Applicant: CK Hutchison Networks (UK) Ltd

Proposal: Proposed 15.0m Phase 8 Monopole C/W wrapround Cabinet at base and associated ancillary works.

2.1. The application seeks prior approval for the installation of a Proposed 15.0m Phase 8 Monopole C/W wrapround Cabinet at base and associated ancillary works.

PROPOSED H3G CONFIGURATION SITE PLAN

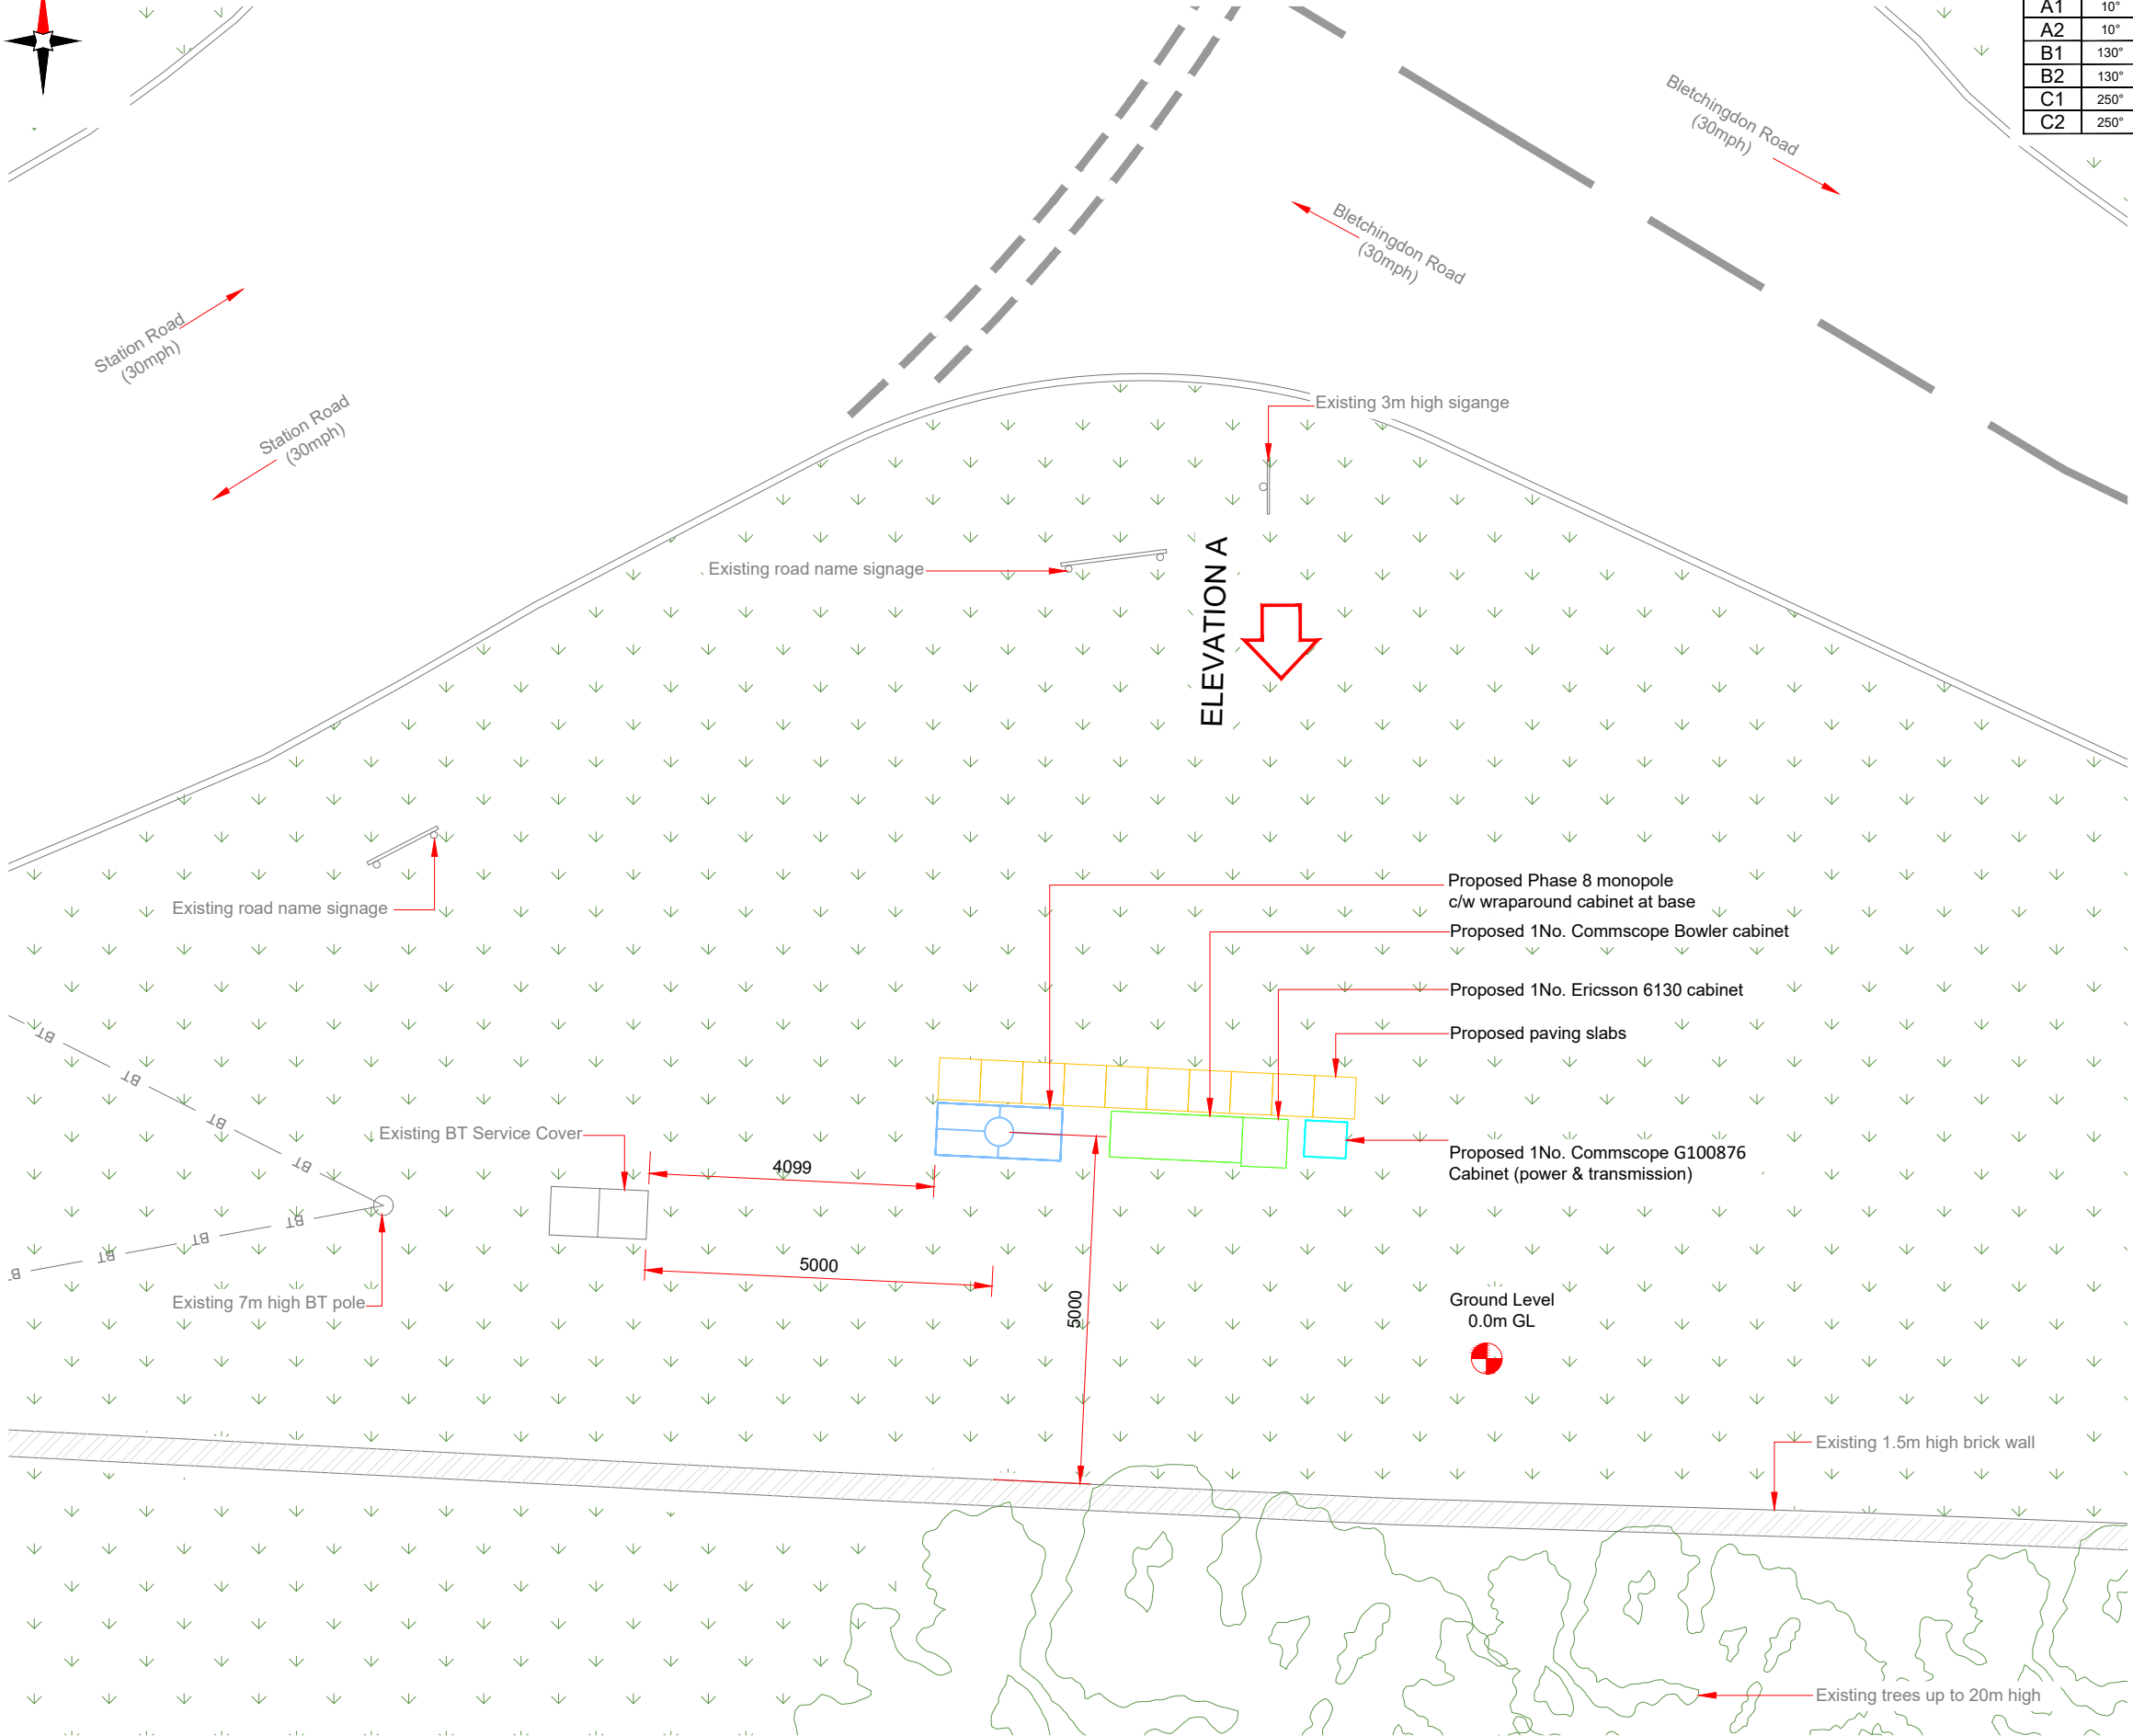
8.3.4 The proposal consists of the erection of a 15.0m Phase 8 Monopole C/W wrapround Cabinet at base and associated ancillary works, on highway land adjacent to a dry-stone wall within the Kirtlington Conservation Area. The proposed development would be visually prominent when viewed from adjacent properties or from the streetscene within the Conservation Area, the proposal would also impact on views of the Grade II* Church Tower, when approaching the Village from the west.

Title: **260 PROPOSED ELEVATION**

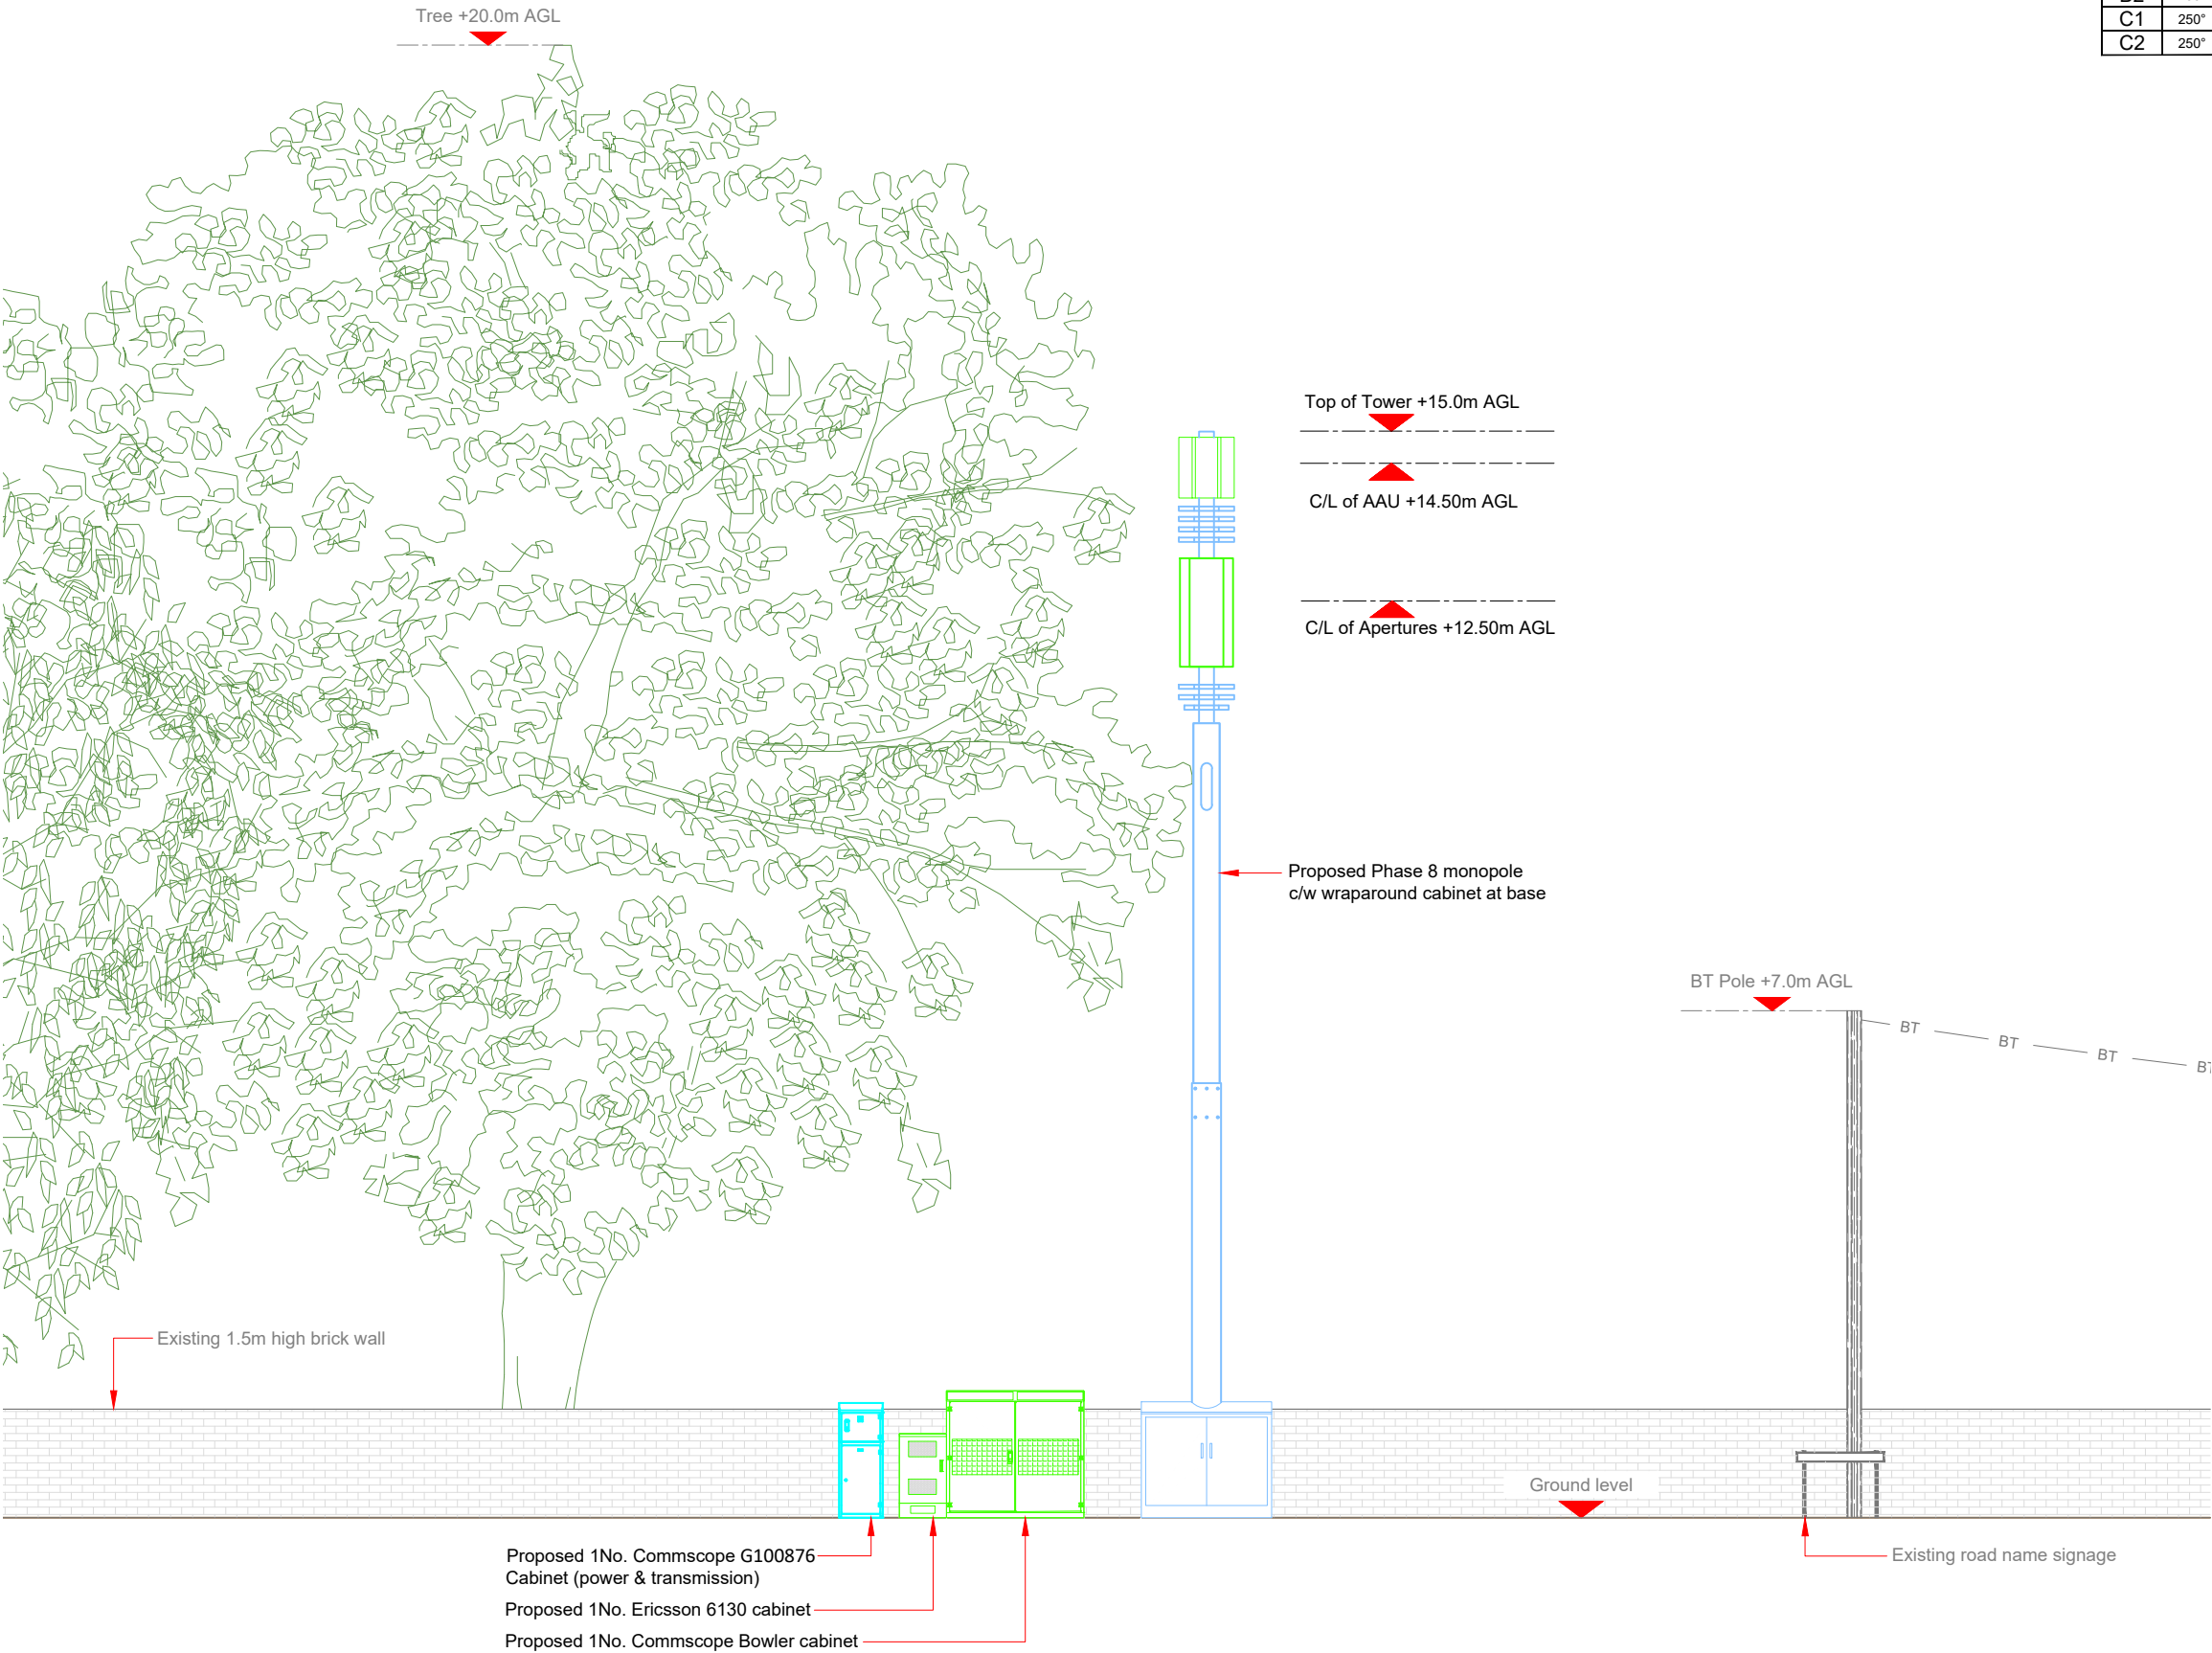
- 8.3.6 The proposed mast would read as a large and visually incongruous addition to the Conservation Area, and while it is noted that the applicant has offered a change in colour to help the proposed mast and equipment integrate into the street scene and that this could be conditioned, it is not considered that this would be sufficient to reduce the harm from the proposal to an acceptable level.

1. The proposed 5G radio monopole and associated equipment by reason of its design and siting would result in less than substantial harm to the character and appearance of the Kirtlington Conservation Area. The identified public benefits are not considered to overcome the harm identified. The proposal would therefore fail to accord with Policy ESD15 of the Cherwell Local Plan 2011-2031 Part 1, saved Policy C28 of the Cherwell Local Plan 1996 and Government guidance set out in the National Planning Policy Framework.
